PRE-SUBDIVISION SITE GRADING ACKNOWLEDGEMENT
AND RIGHT OF ACCESS FORM

The undersigned (“Applicant”) owns and holds legal title to the real property to be known as Grandview Reserve Phase 2 (“Property”), which Property is legally described on Exhibit A attached hereto and incorporated herein by this reference.

Applicant seeks approval for Pre-Subdivision Site Grading under Section 6.2.6 of the El Paso County Land Development Code. As a condition of approval and issuance of Construction Permit No. _____, Applicant must complete and submit this Pre-Subdivision Site Grading Acknowledgement and Right of Access Form. In compliance therewith, by signing below, Applicant hereby acknowledges and agrees as follows:

EXHIBIT B

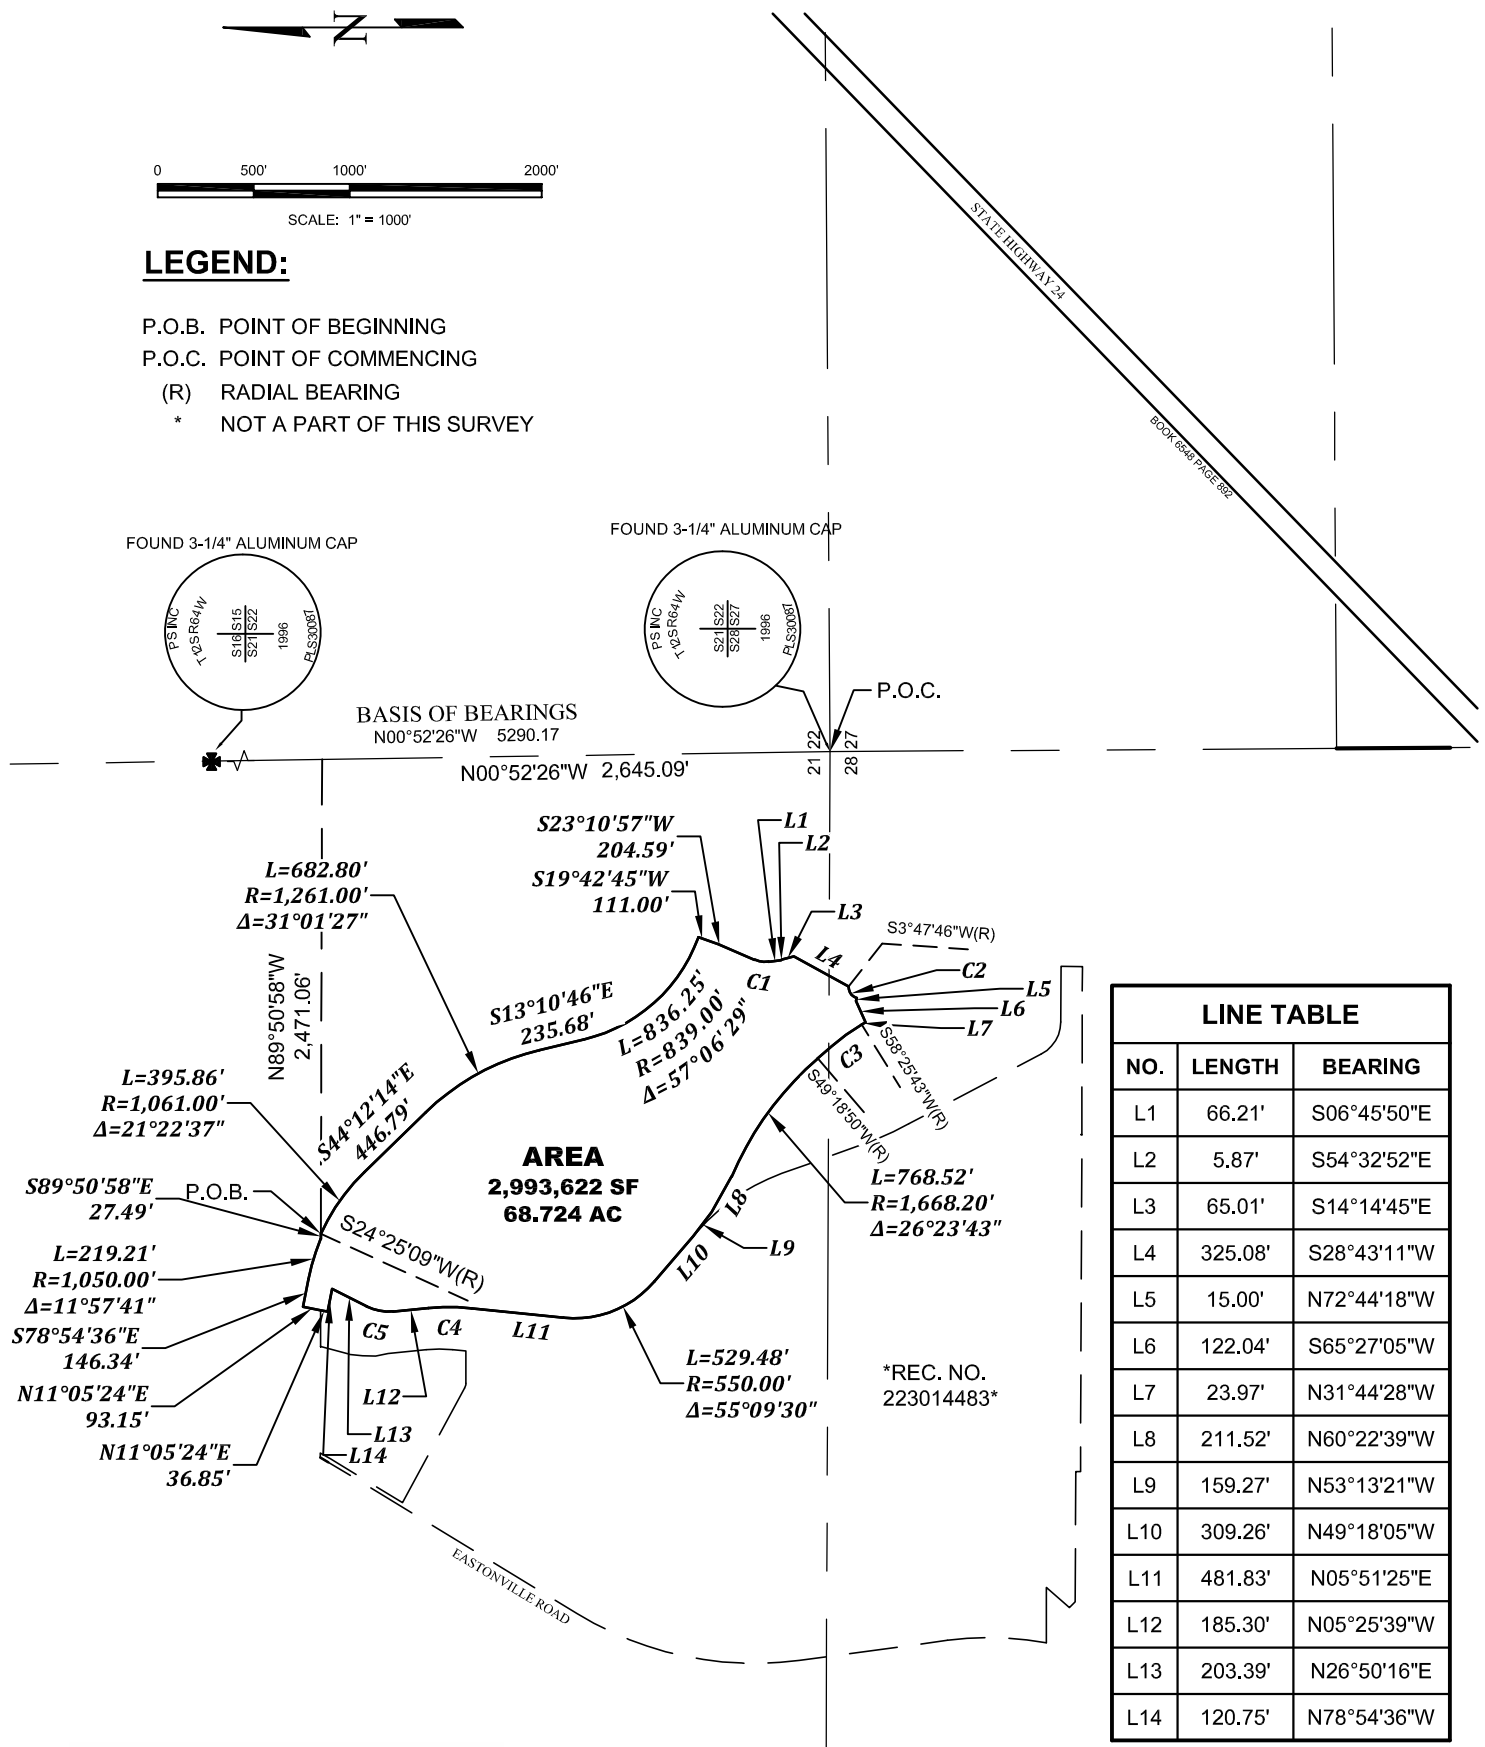
Include this as part of exhibit A.
Exhibit B will be GEC Plans and
FAE as noted in agreement.

HRG RESPONSE:
Exhibit B heading removed
